**Re: Submission on behalf of One Darling Harbour _Harbourside Shopping Centre
RTS_ SSD7874 (the RTS)**

This submission is made in response to the amended design and documents submitted by the proponent in its Response to Submissions dated October 2020 (**RTS**) and exhibited by DPIE (**Amended Design**).

**Figure 19** 50 Murray Street – worst affected apartments

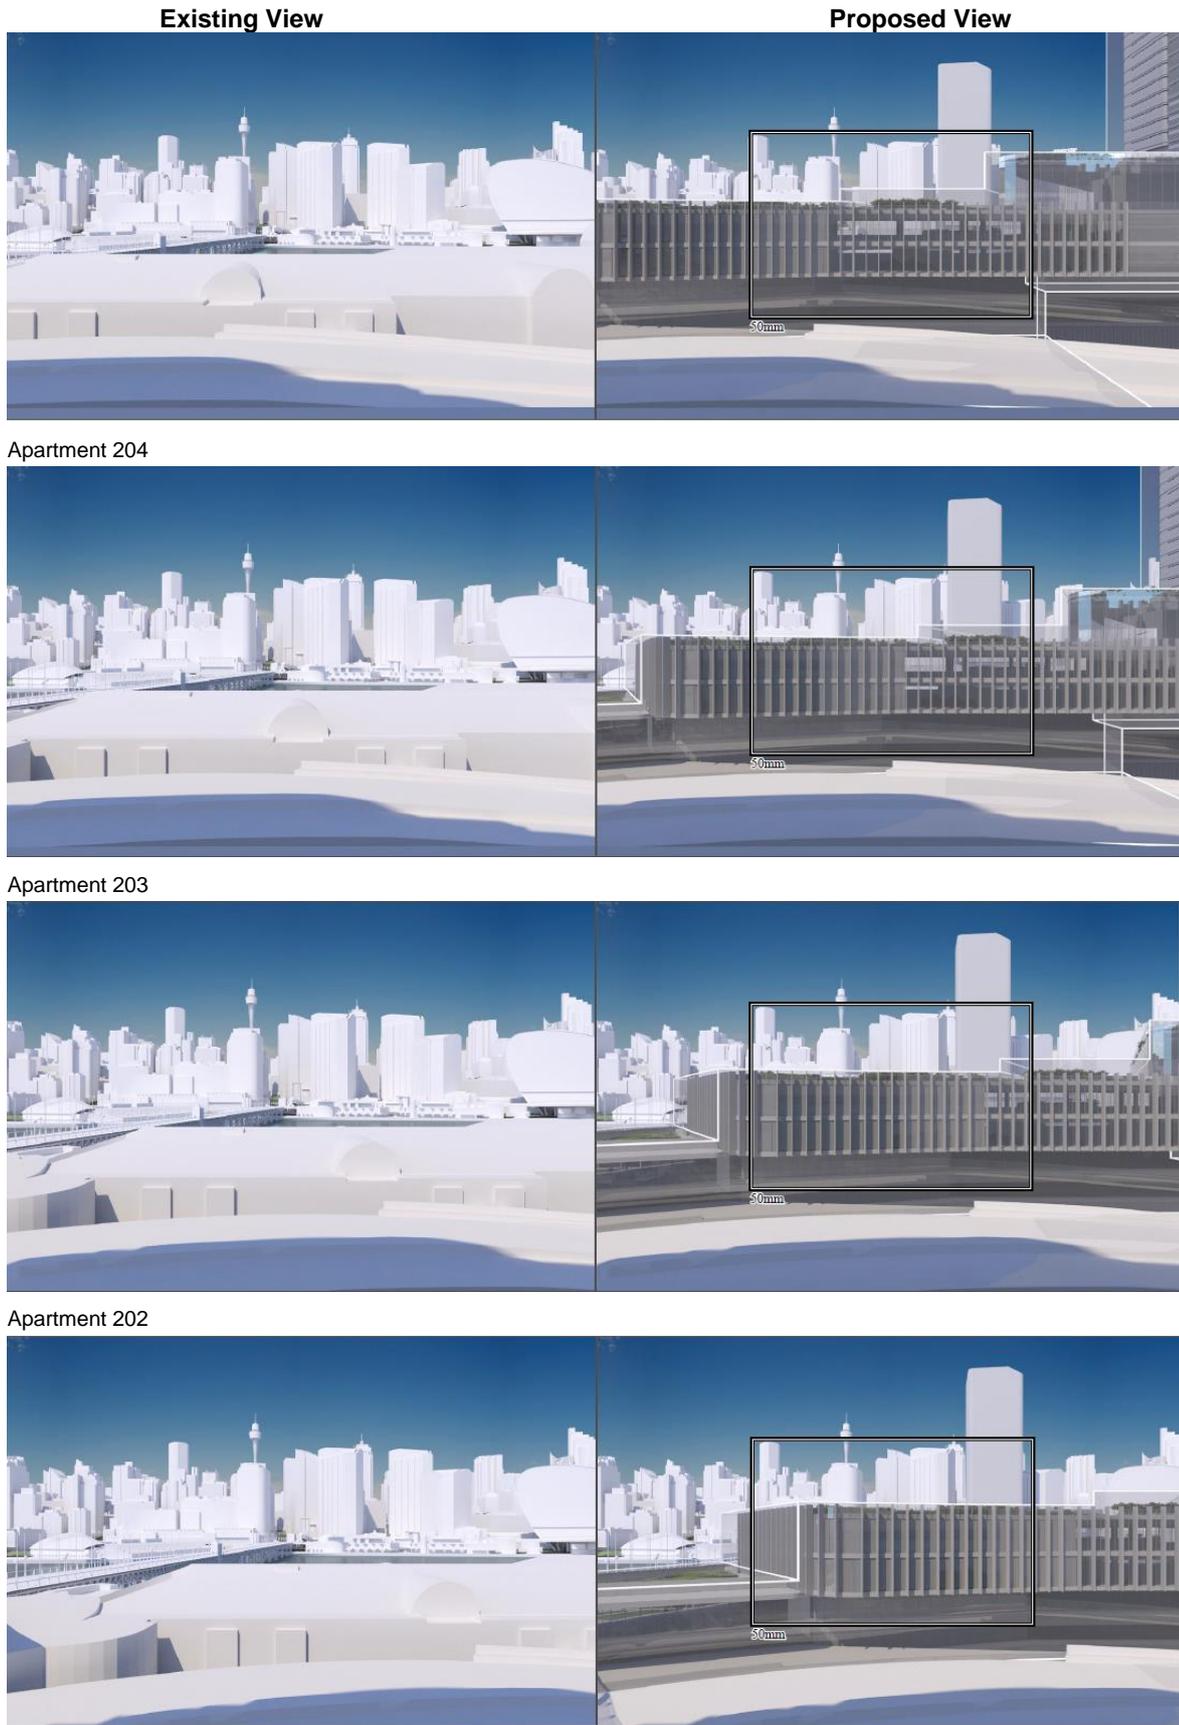
Our client appreciates that the Applicant has at last provided detailed CGI images to represent the likely future impact of the proposal on views from residential apartments at One Darling Harbour. Our client notes that these CGI images confirm that:

- 104 apartments and the east facing common areas of One Darling Harbour will have views adversely impacted by the proposal (in that South and South East cityscape views will be blocked)

- 48 of these will lose all, or substantial key elements of, the valuable iconic water views they currently enjoy.

Our client and its expert (Dr Richard Lamb) disagree with the characterisation of the severity of this view impact provided by the proponent. Dr Lamb's report is attached. In Dr Lamb's expert opinion the Amended Design benefit a total of four apartments in One Darling Harbour, 2 at each of Levels 2 and 3, as a result of lowering of part of the northern section of the podium. The overall view impacts to an extent that is moderate to severe would remain for a further 49 apartments.

We note that these significantly affected apartments are home to approximately 150 residents. We also note that in Dr Lamb's opinion the view impact images provided tend to underestimate the actual impact of the proposal as:

- the impacts have been assessed using CGIs representing views from the extremity of balconies, other than for one view from communal space on the roof of One Darling Harbour. This should result in extra weight being given to impacts on the whole apartments. The result however is under-estimating the likely impacts on internal view; and
- the building envelope is significantly larger than the exemplar building depicted in the images.
